December 09, 2022

Re: [#2022091] – Avanzando Development (Rio Bravo Blvd. / Loris Dr.)

Following are your comments from your memo dated March 24, 2022 and my responses:

## Avanzando Conceptual Site Plan

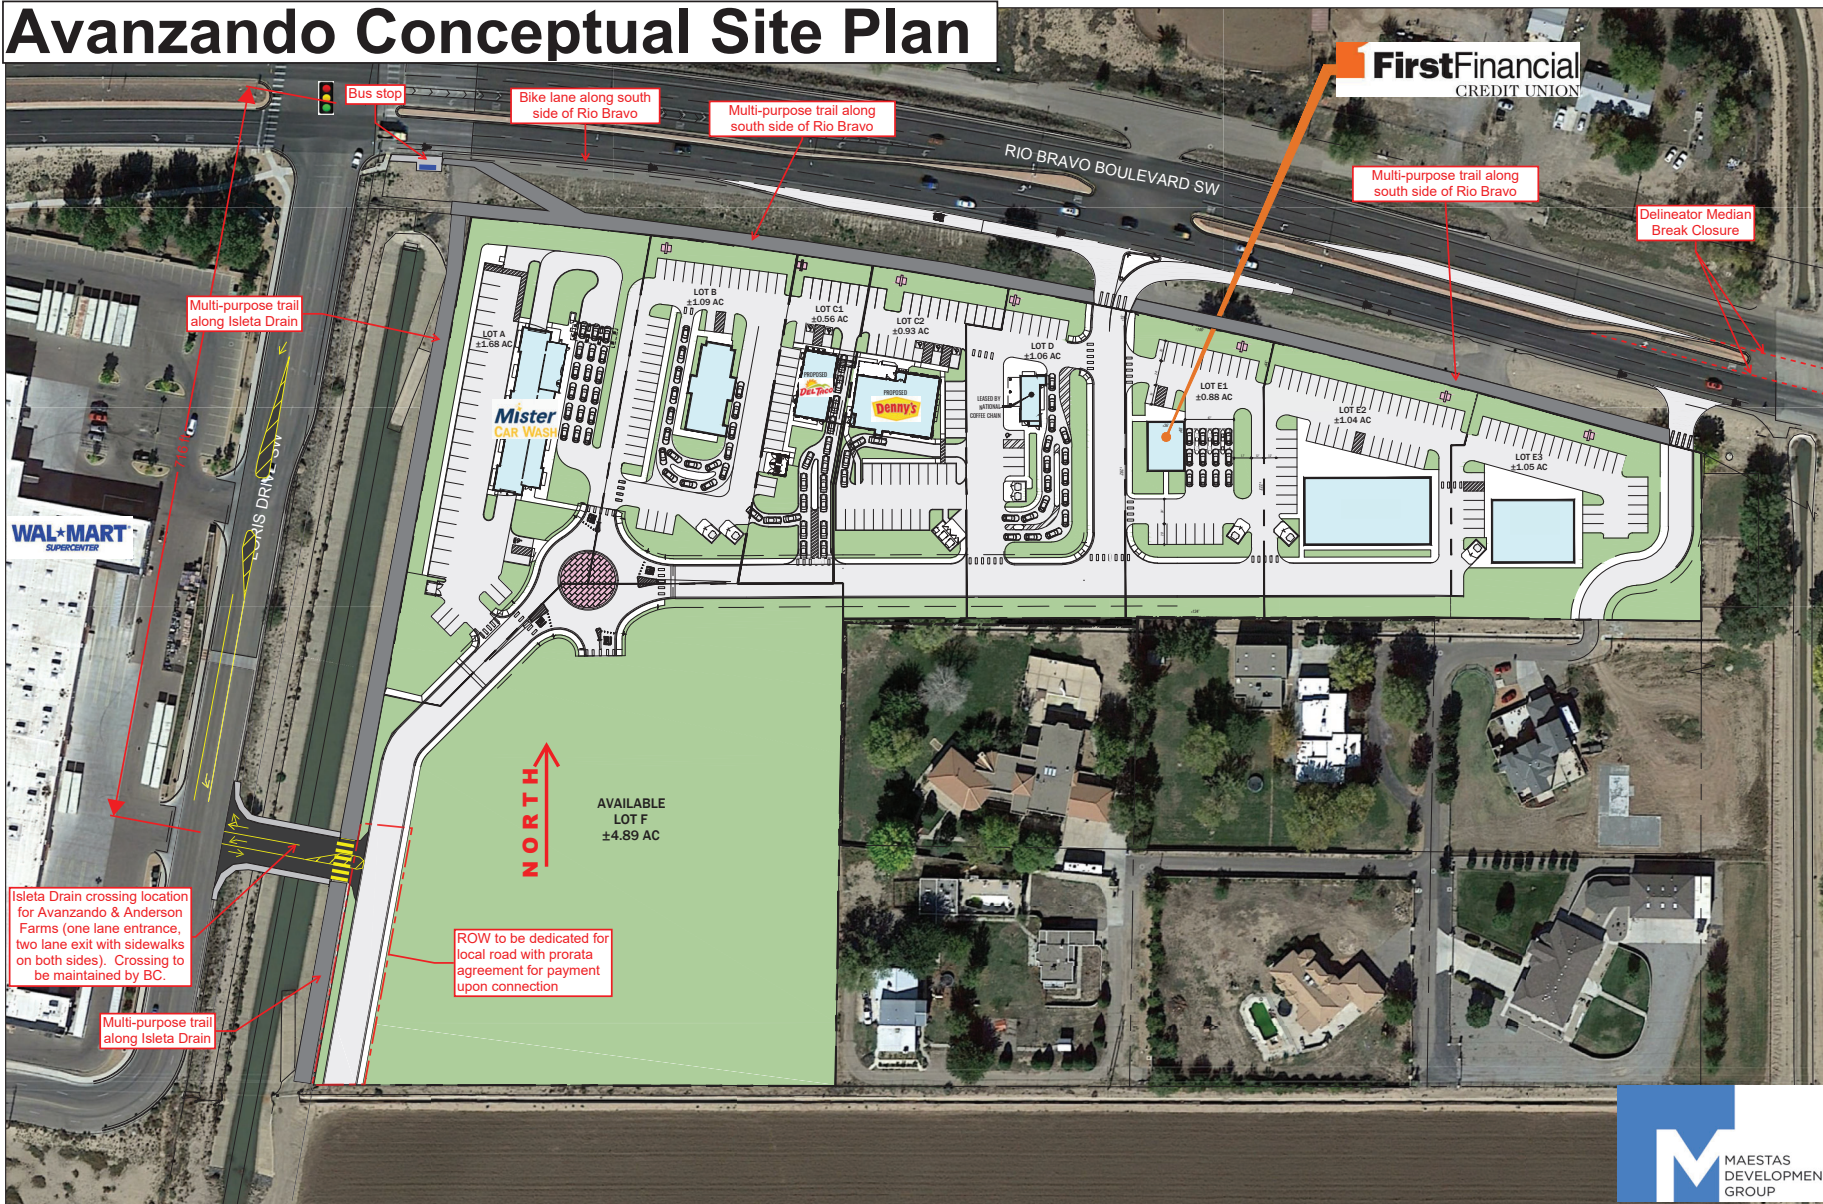
Comment: A shared access easement shall be platted on the southern edge of this property for a potential future shared access with Anderson Farms to the south. Consideration should be made to connect to Loris in the future to connect to the existing signalized intersection at Loris. If that connection is to made it the future, modifications to the intersection of NM 500 and Loris may be required.

Response: Complied. The future access easement is shown on the site plan.
